# CITY OF ALBUQUERQUE

March 25, 2019

**RE: Signal Village Subdivision  
Signal and Ventura NE  
Grading Plan Stamp Date: 2/20/19  
Drainage Report Stamp Date: 2/20/19  
Hydrology File: C20D078**

Based upon the information provided in the submittal received on 2/20/2019 the above-referenced project cannot be approved for Preliminary Plat, Work Order, or Grading Permit until the following are addressed.

Drawing file: 2018-05-11 / EXHIBIT A - 5.10.18.pdf

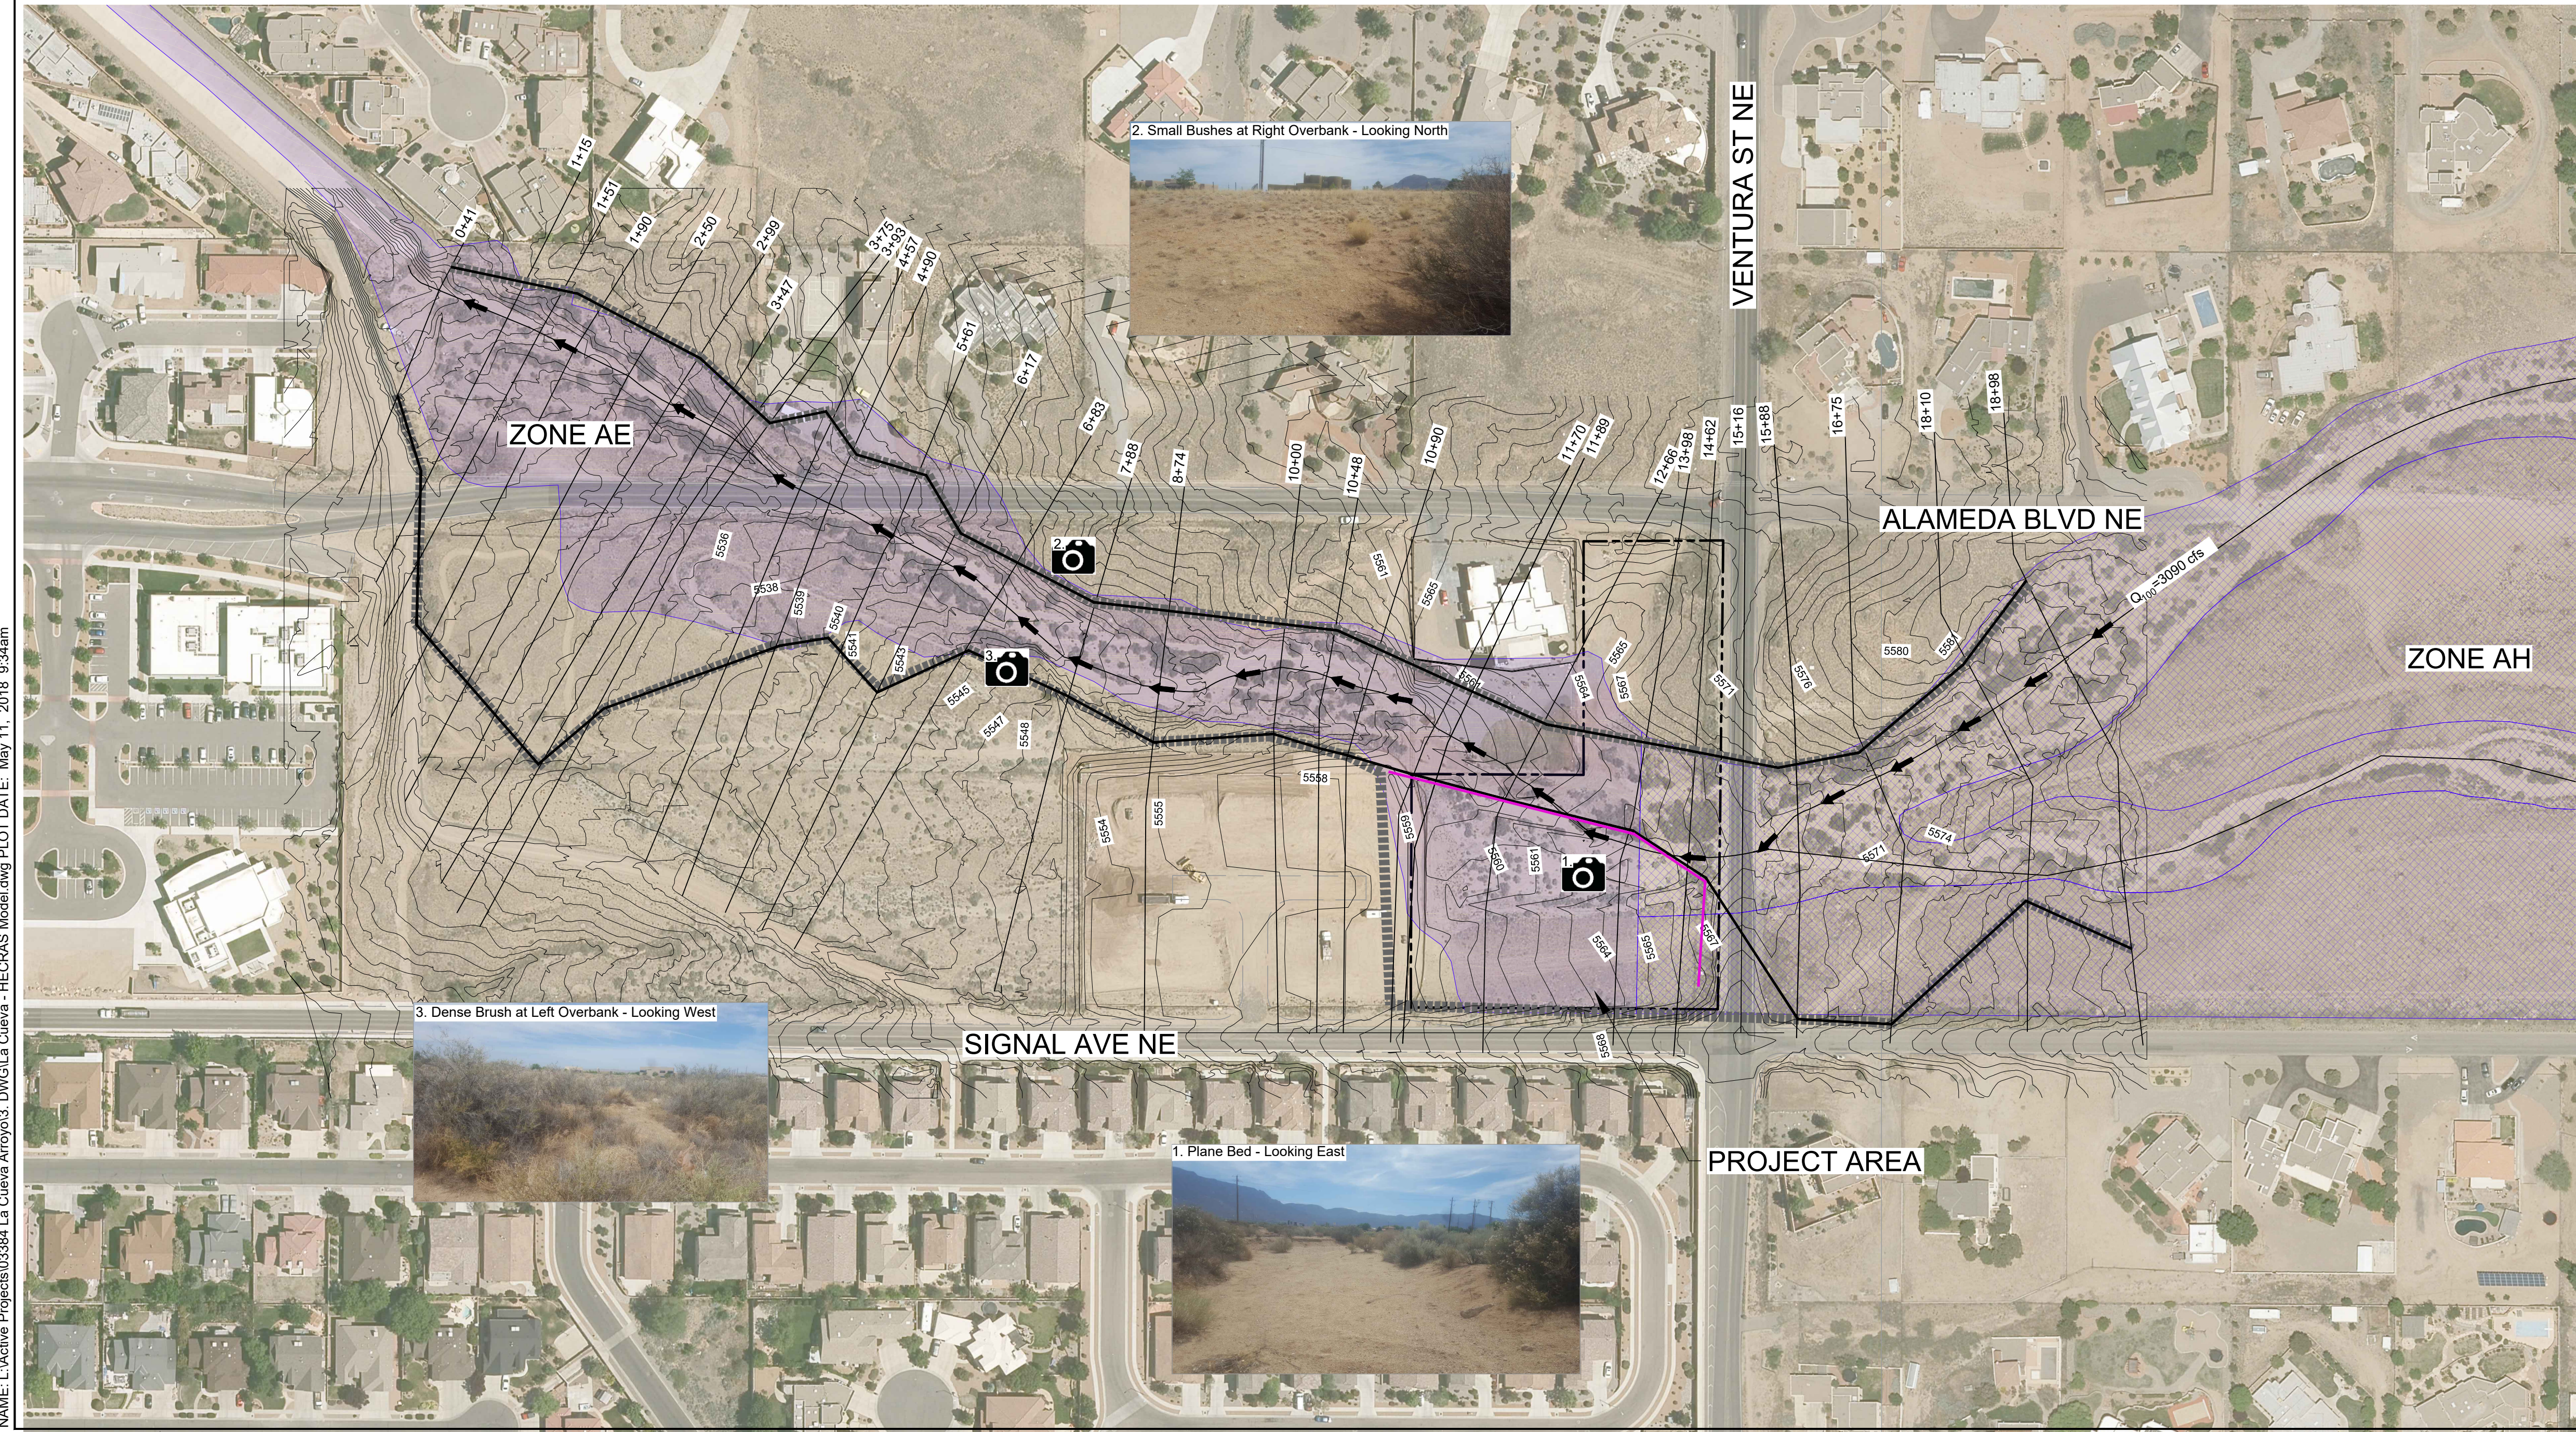
- e. Correct the scale of the Topo Work Map, Exhibit A, and identify the source of topography, surveyor name, registration number, date and datum of survey. Show

- h. Add the duplicate effective water surface elevations to the table on "Exhibit A", the Topo Work Map, and compare to the corrected effective elevations. Add a narrative comparison of duplicate effective to corrected effective and a comparison of corrected effective to proposed elevations in a new "Conclusions" section in the report.
